From: Gareth Lewis [REDACTED]
Sent: 24 September 2020 19:40
To: Planning <Planning@arun.gov.uk>
Subject: Application reference M/59/20/HH

We are writing in respect of the above application. Our address is 43 Southdean Drive which is directly opposite the site in question.

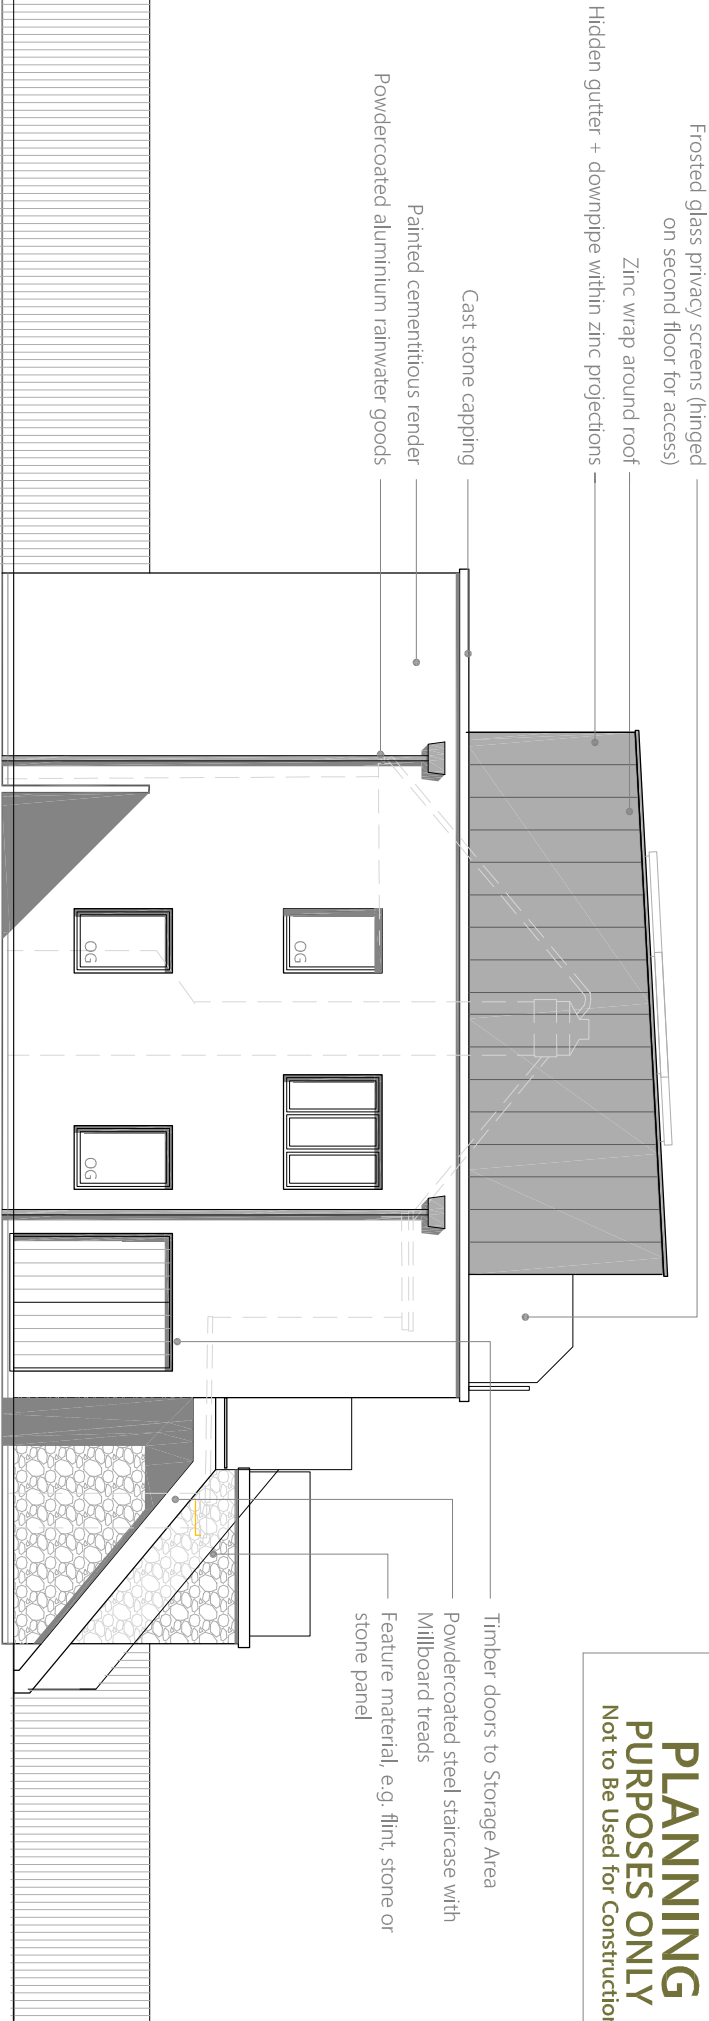
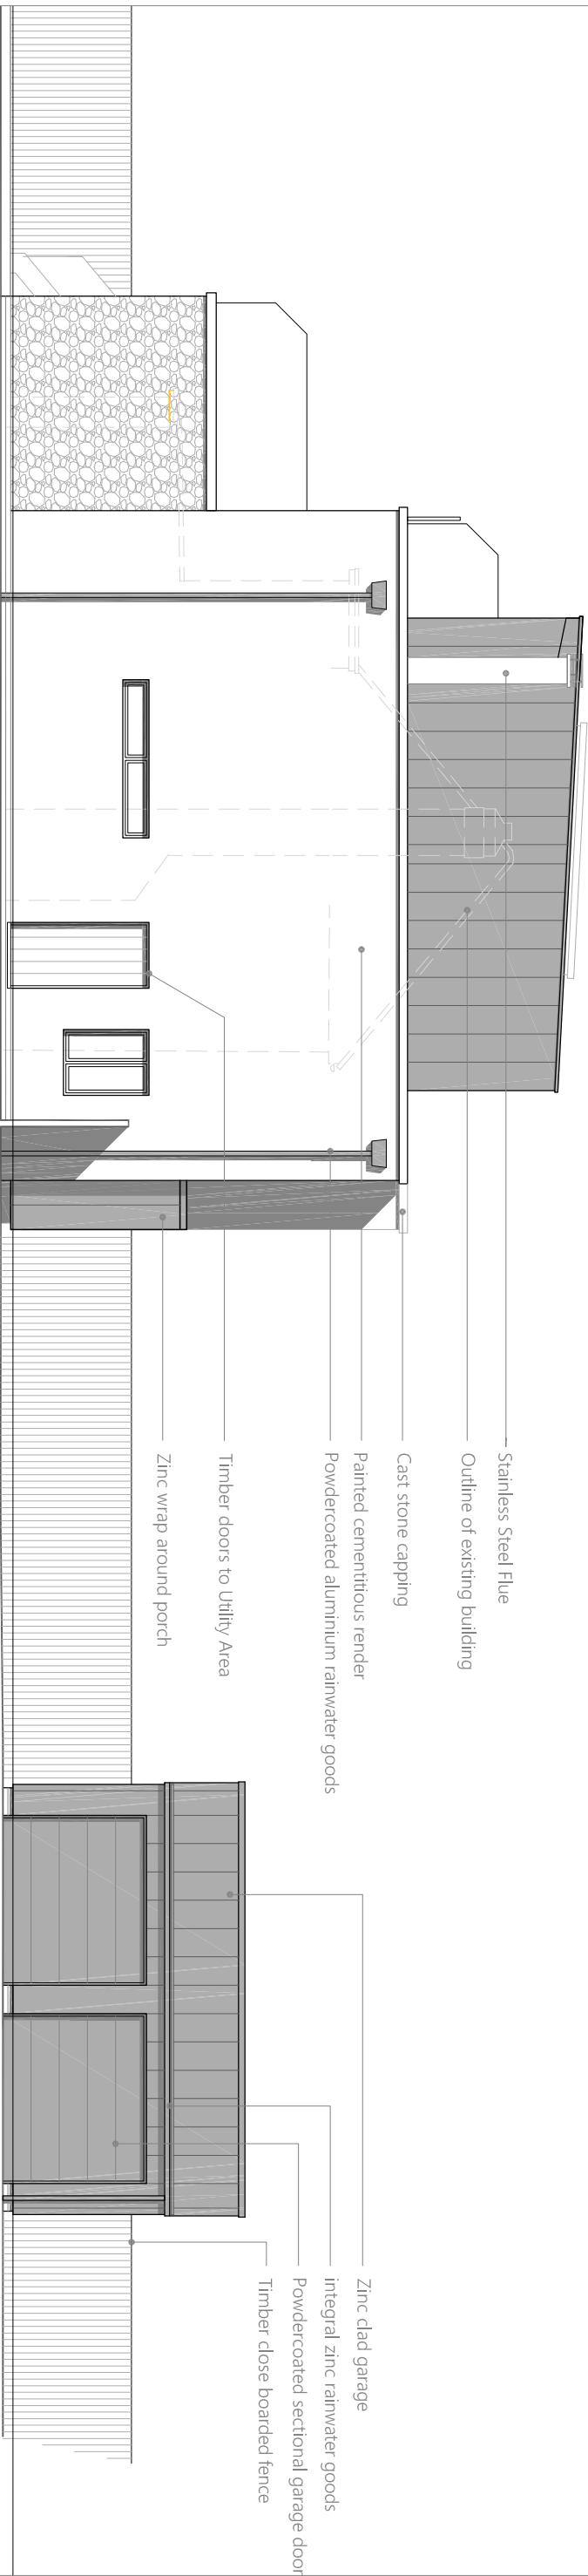
The extensive use of Zinc, dark grey window surrounds, stainless steel flue and - it appears - dark cladding boards give an industrial appearance to the overall building.
